Thank you for the opportunity for a submission to SSD-8873789, regarding the proposed new Epping South Primary School.

After reviewing the planning documents, and in particular *Appendix 23 'Transport Access Impact Statement'*, we and many other residents of Second Avenue have serious concerns regarding the traffic flow. As residents of Epping for 40+ years, we feel this planning has not been considerate or respectful to the residents of Second Avenue. Our objections can be summarised as below:

Figure 21 Proposed access points (Source: Pedavoli Architects)

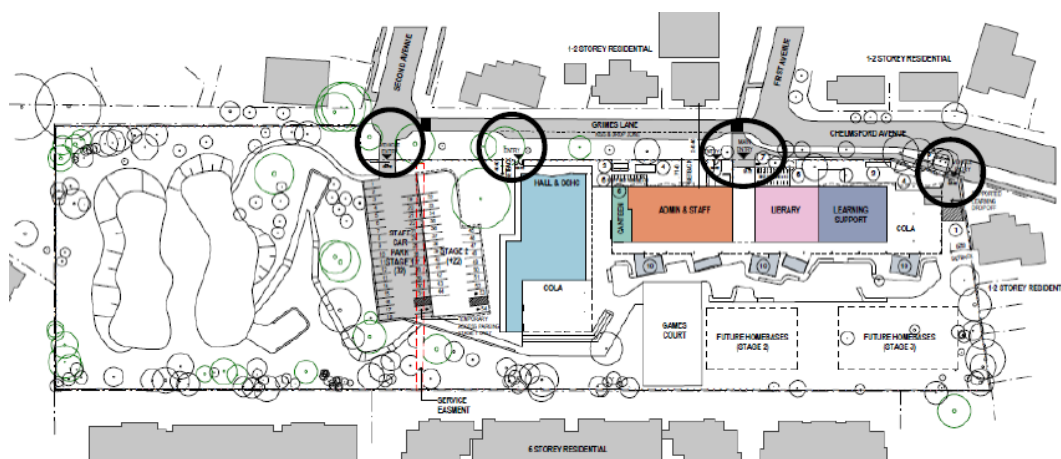
1. The traffic flow is funnelled onto Second Avenue, an existing quiet cul-de-sac;
2. Second Avenue has been a longstanding quiet cul-de-sac that has always opposed the opening of Grimes Lane;
3. The additional unnecessary carpark access from Second Avenue;
4. The impact to street parking for residents;
5. The land use and road network assumptions made in *Appendix 23 'Transport Access Impact Statement – NPES'*.

Figure 30 Proposed civil works to Grimes Lane (Source: PTC)

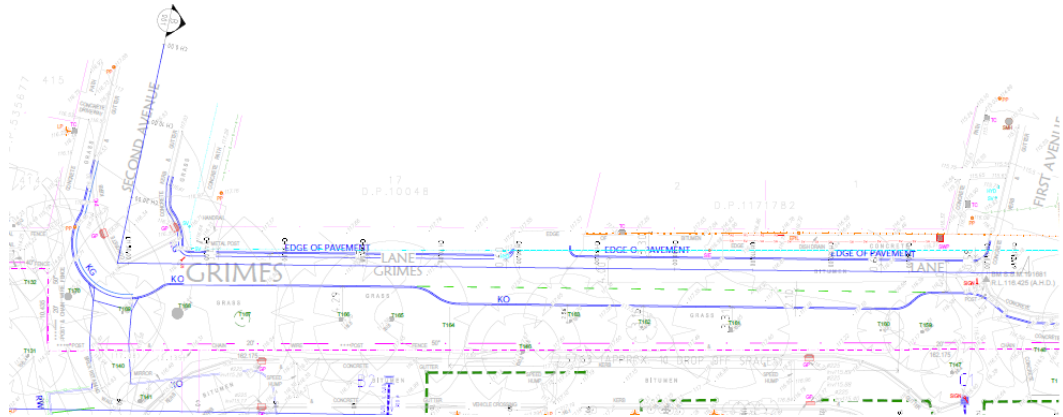
8. This leads to the access issue – the one-way westbound operation on Grimes Lane pushes all the school's traffic onto Second Avenue. From the Kiss and Ride points and accesses to the carpark, majority of this traffic will traverse Second Avenue, exceeding the serviceable capacity of this street (notwithstanding the issues of parking capacity, likely to push staff or families to park on Second Avenue as well). This issue is concerningly vague within the report, as no further assessment of Second Avenue has been pursued and yet it is the most

significant change to the network. Once again, we object to the opening of the cul-de-sac at Second Avenue and the absence of planning regarding car-parking requires further exploration.

There are several alternative traffic flow options that could direct traffic in multiple directions and not disrupt the existing quiet cul-de-sac of Second avenue. These solutions could include widening Grimes Lane to allow for a turning circle and two-way traffic, access to the new carpark from Grimes lane and opening other proximal streets that are in higher density areas such as Ferntree place. We eagerly await your response to these concerns.
